Markup Summary

TIMBERLINE STORAGE YARD - GRADING AND EROSION CONTROL PLAN

TIMBERLINE STORAGE YARD
GRADING AND EROSION CONTROL PLAN
 PROJECT NO. 43-095
 SCALE: N/A
 HORIZONTAL: N/A
 VERTICAL: N/A
 DATE: 07/13/2017
 SHEET 1 OF 8
 GR01

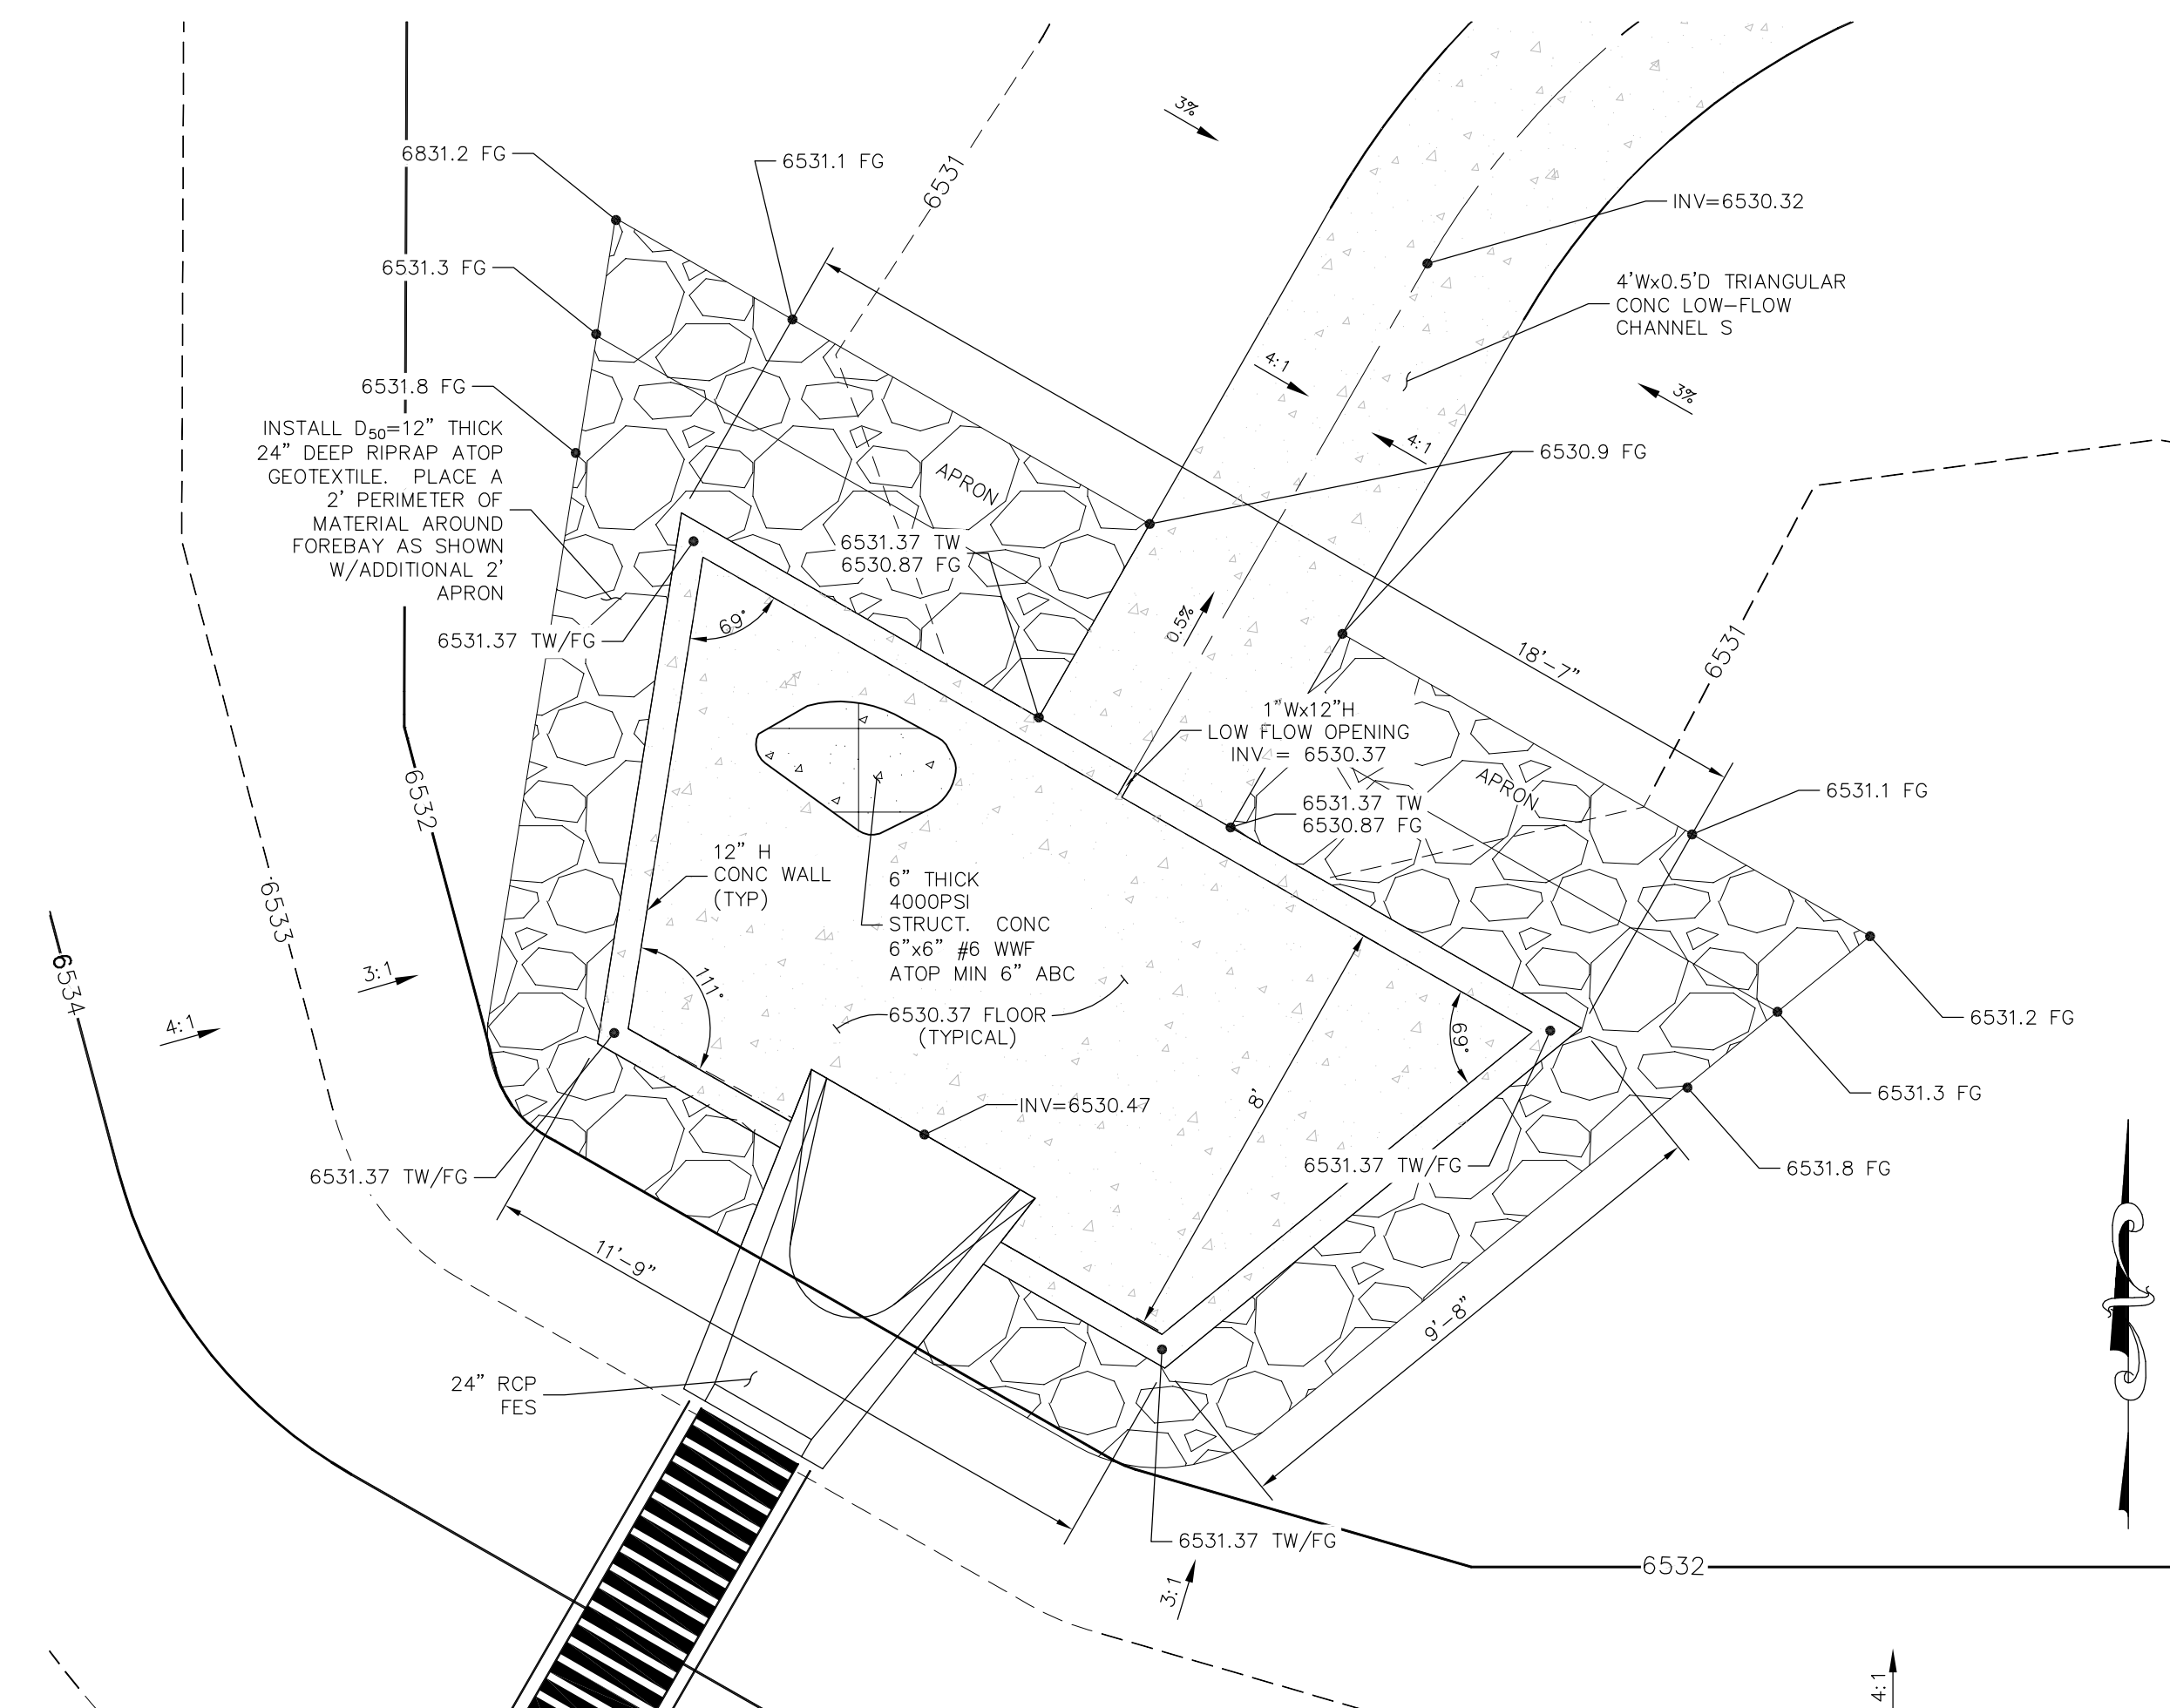
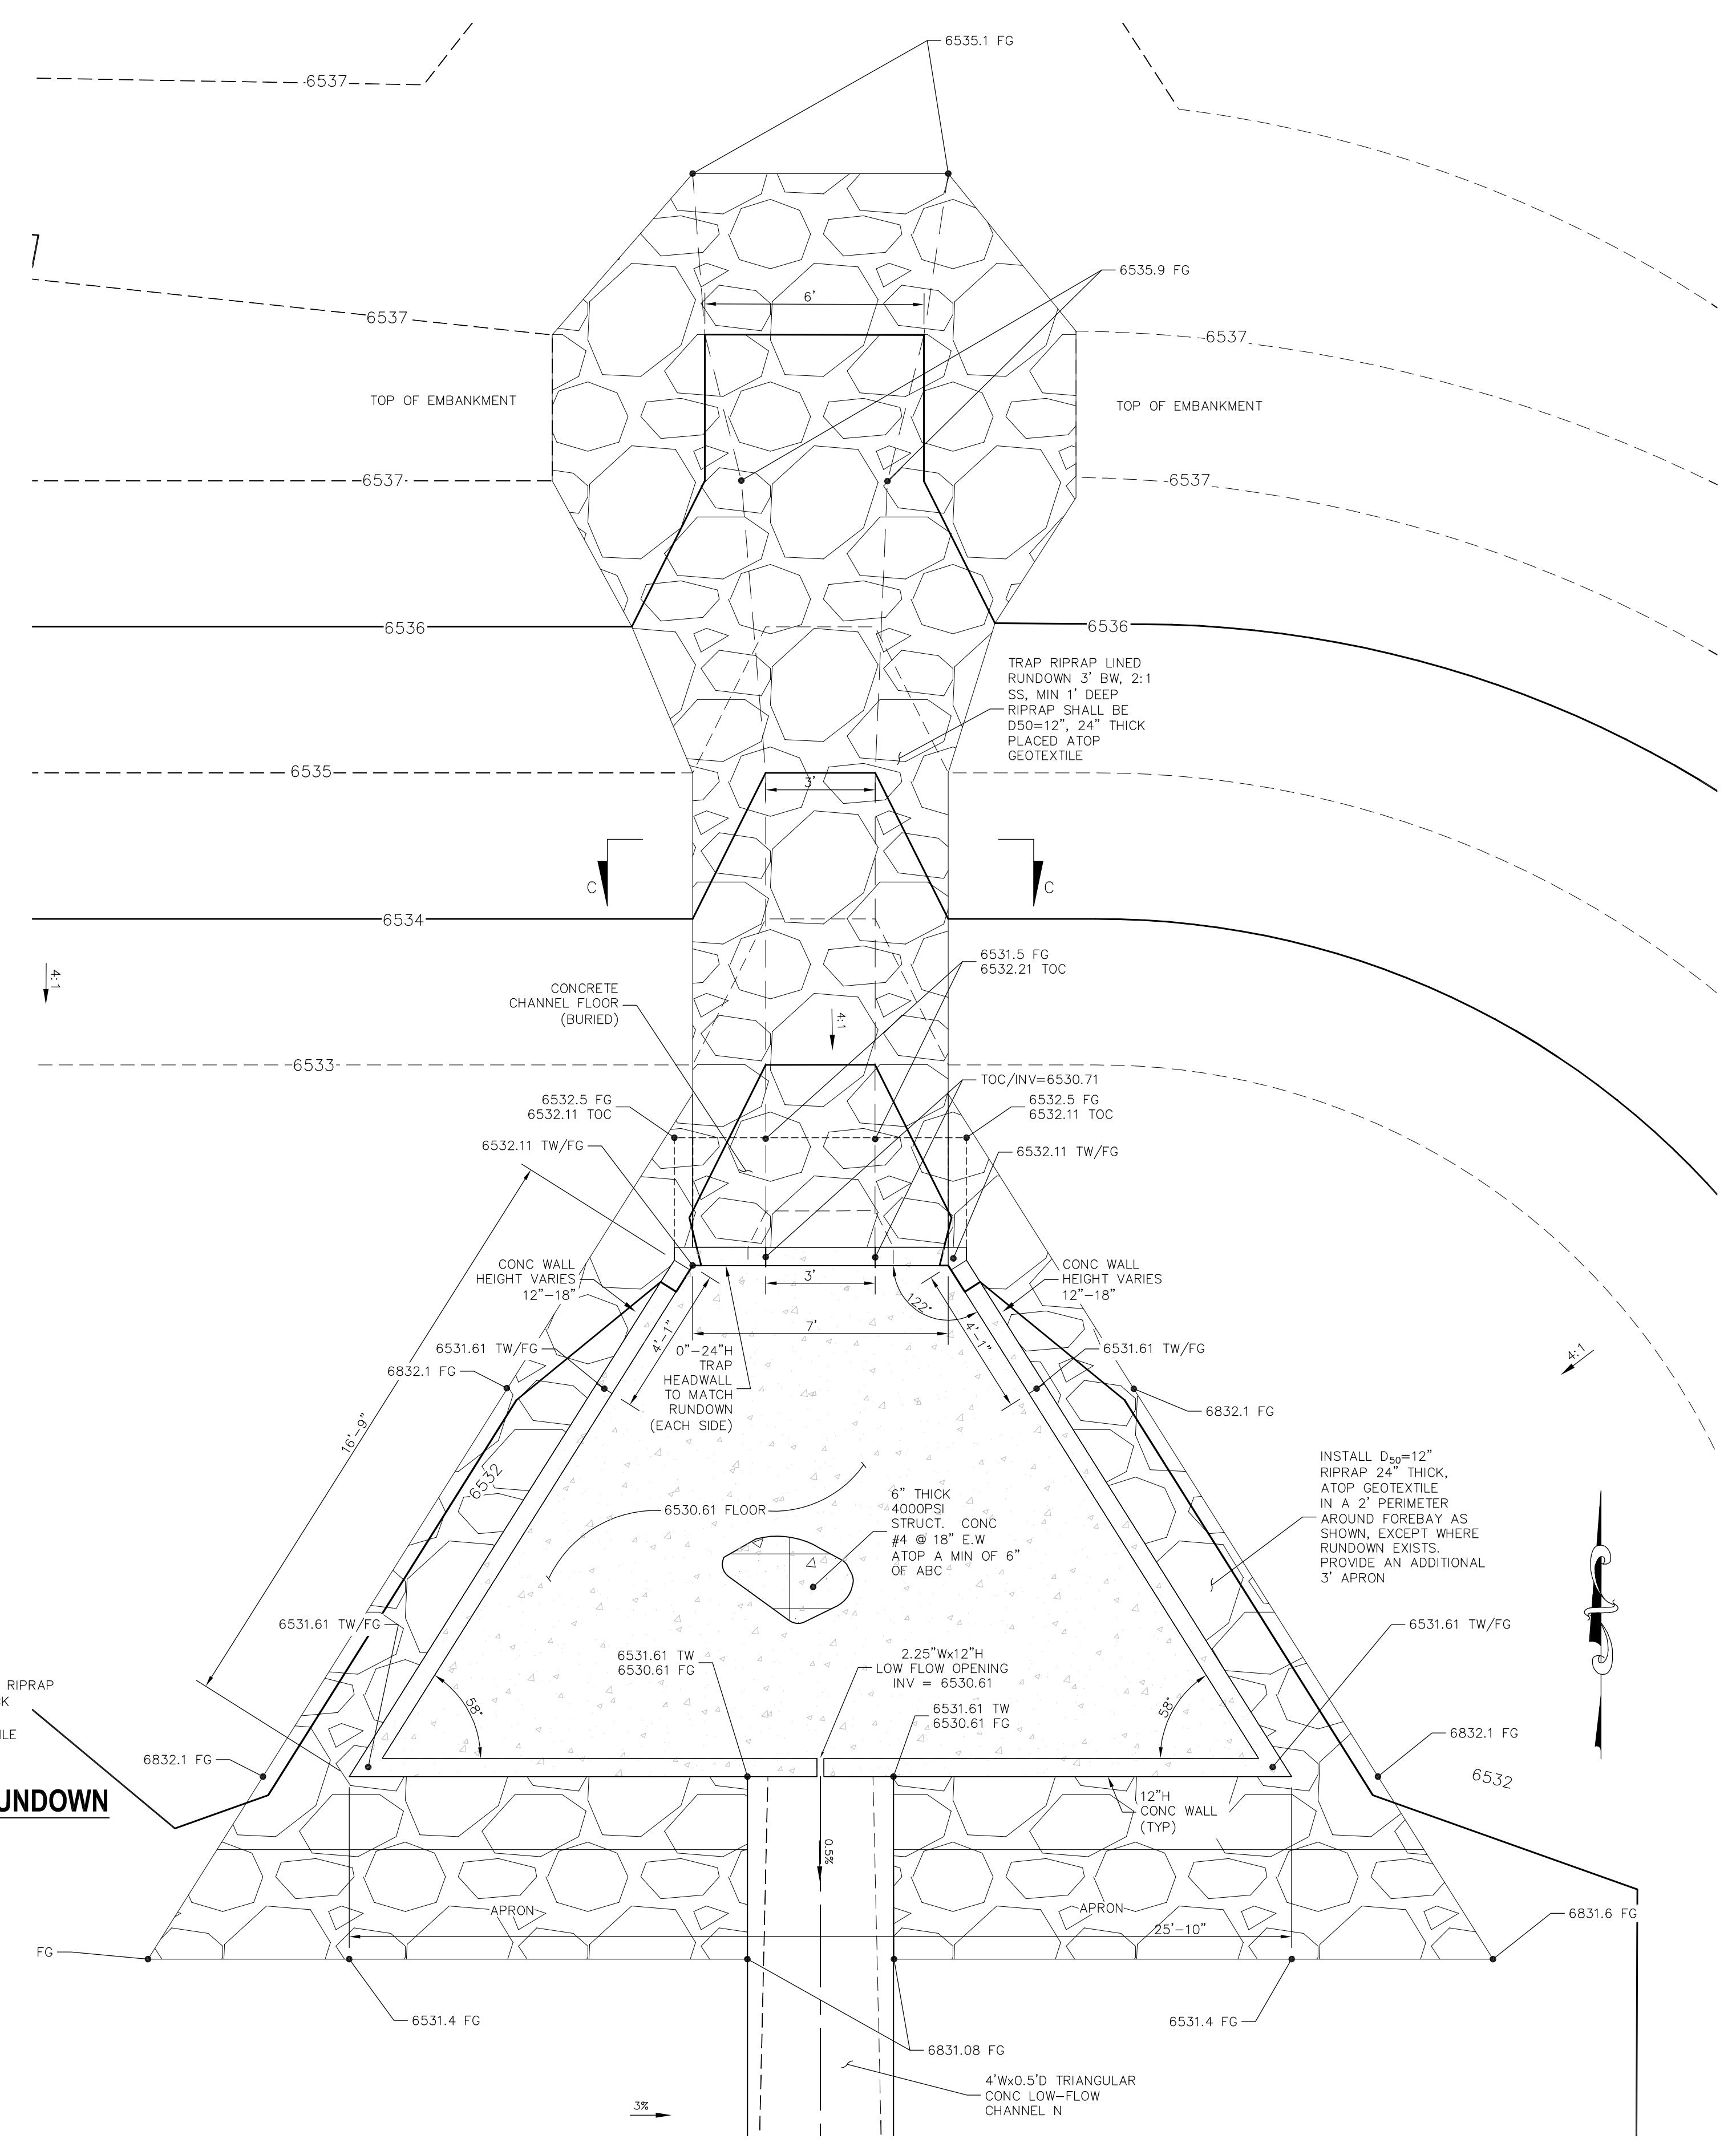
Unresolved.

Label as "Private"

Label as "Private"

Label as "Private"
